June 9, 2020

Re: Sedona Sun Acres Residential Development Letter of Intent

SEDONA SUN ACRES FILING NO. 1

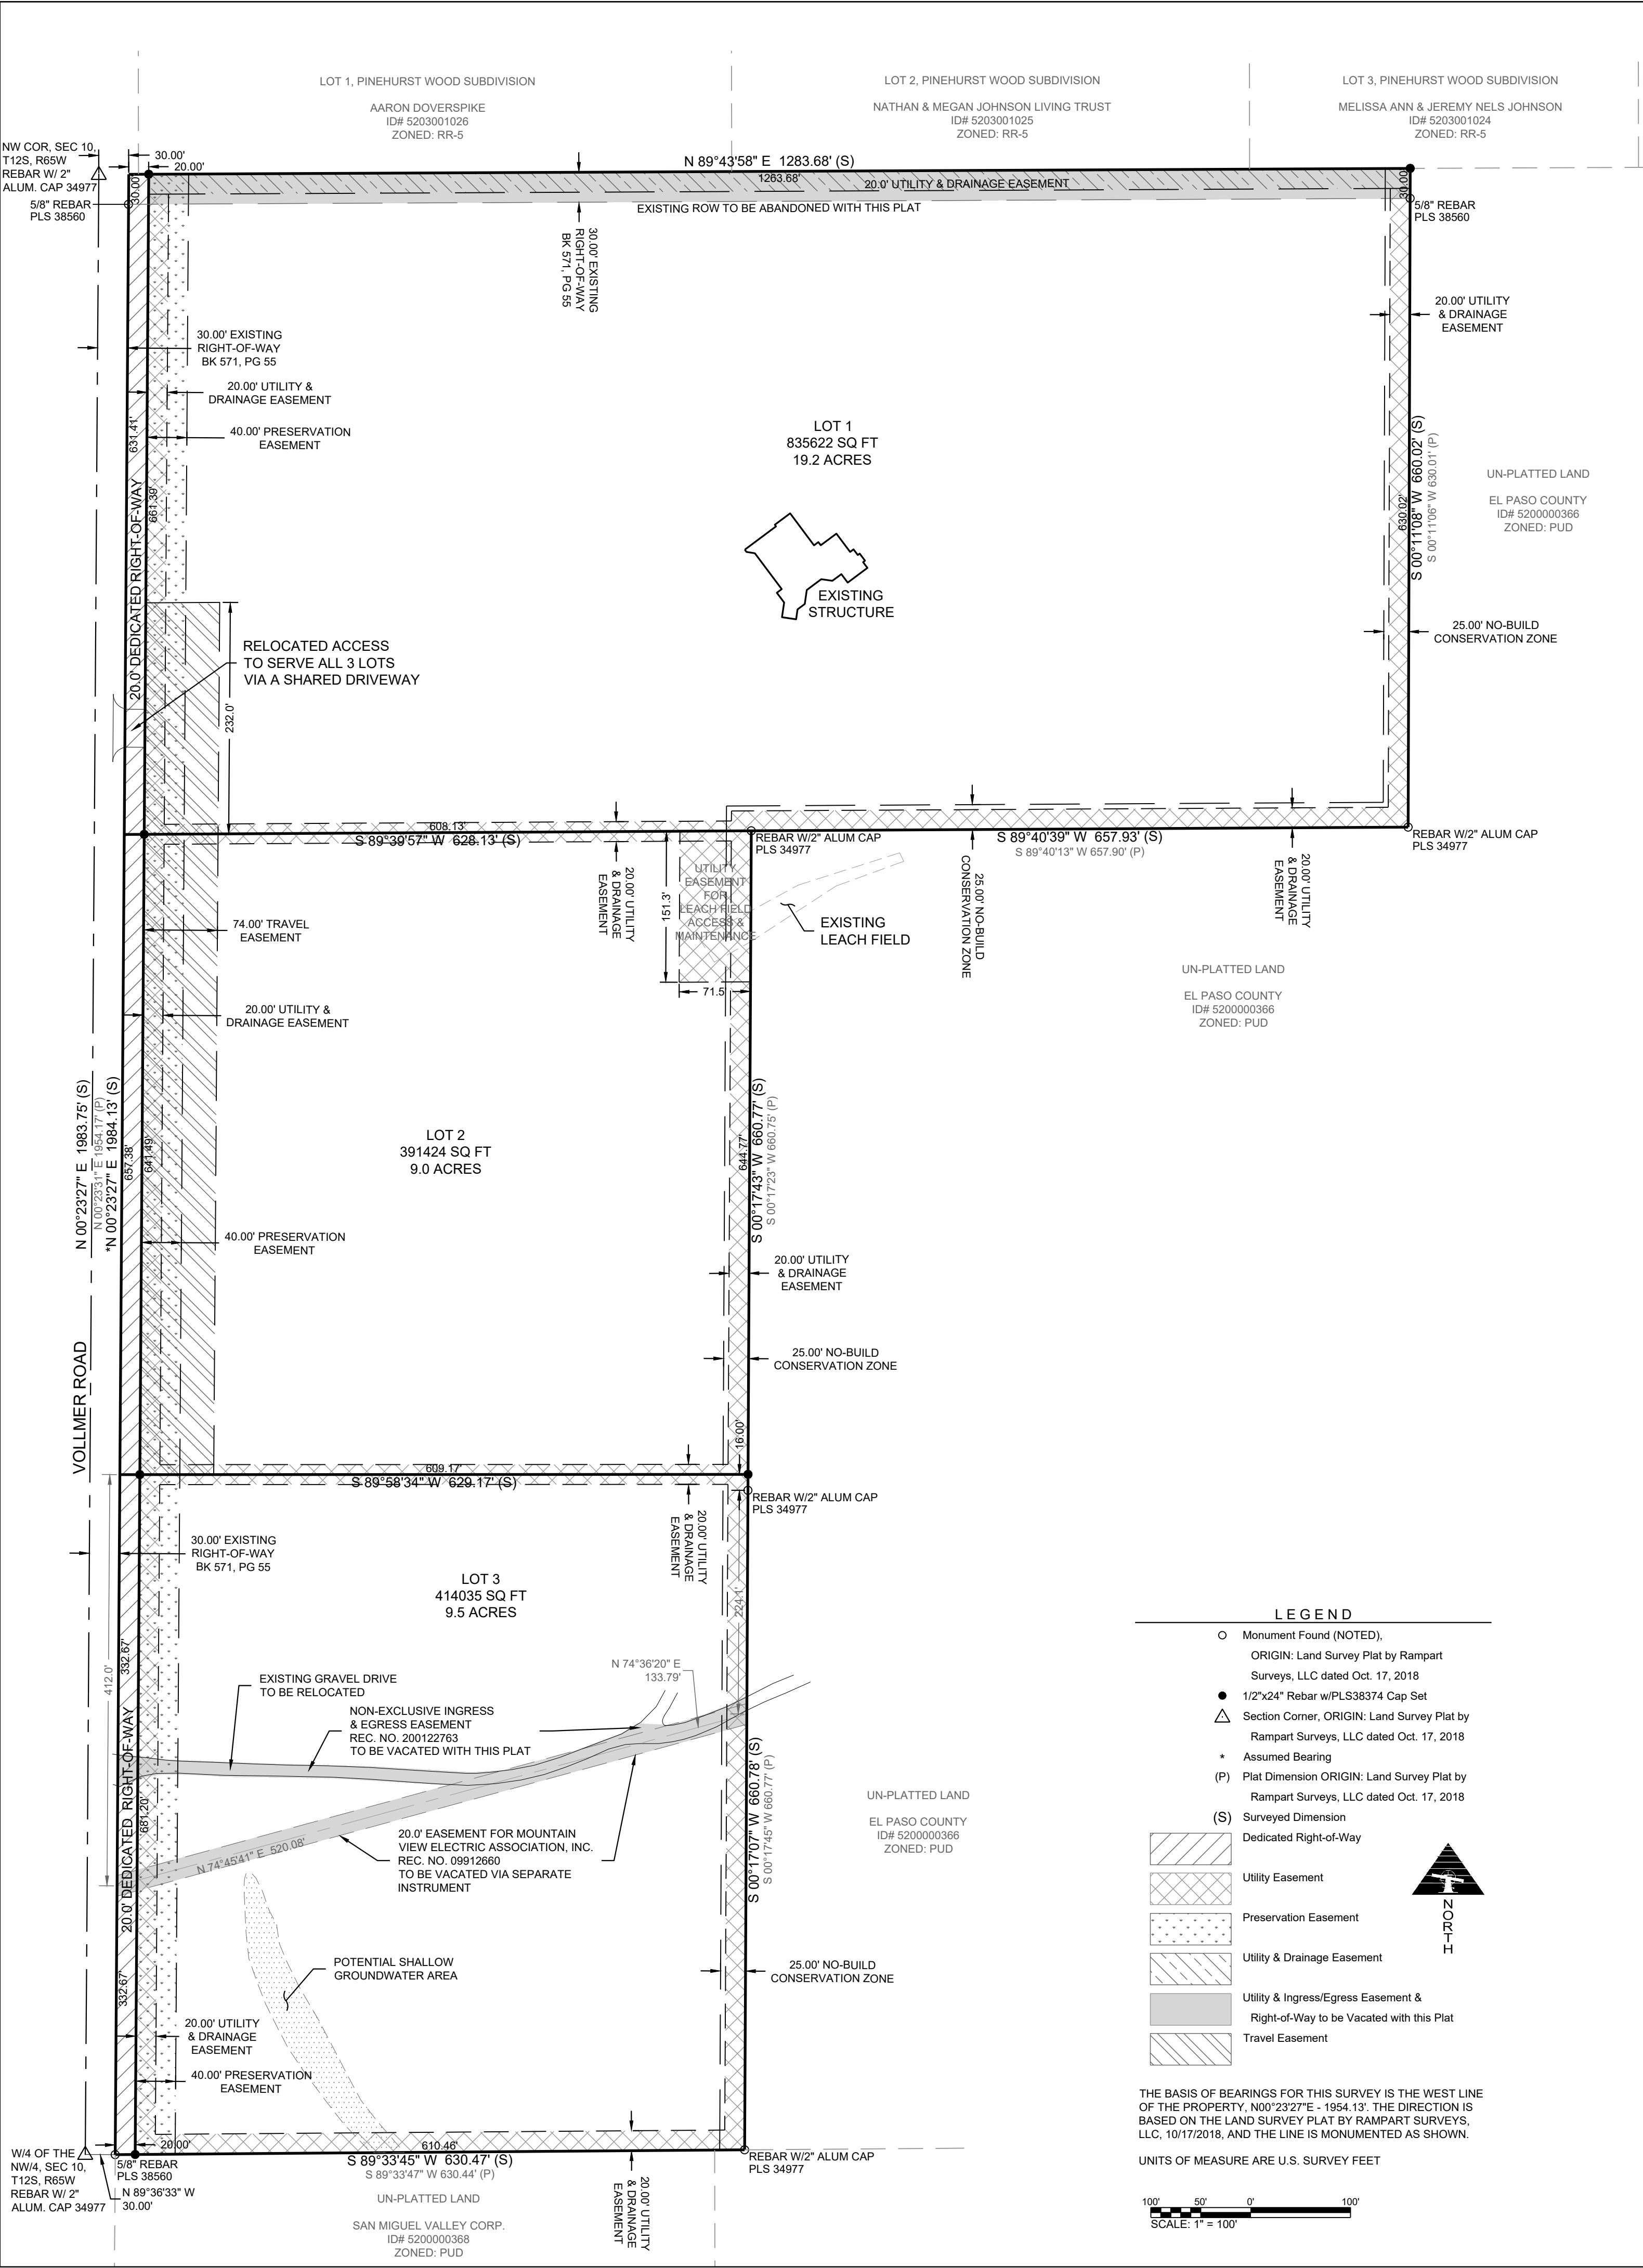
These lot sizes will not be acceptable. RR-5 requires a minimum 5 acres per lot.

Acreages of proposed lots are all different as shown on plat. Revise as necessary.

Multiple access points from Vollmer Road are not permitted.
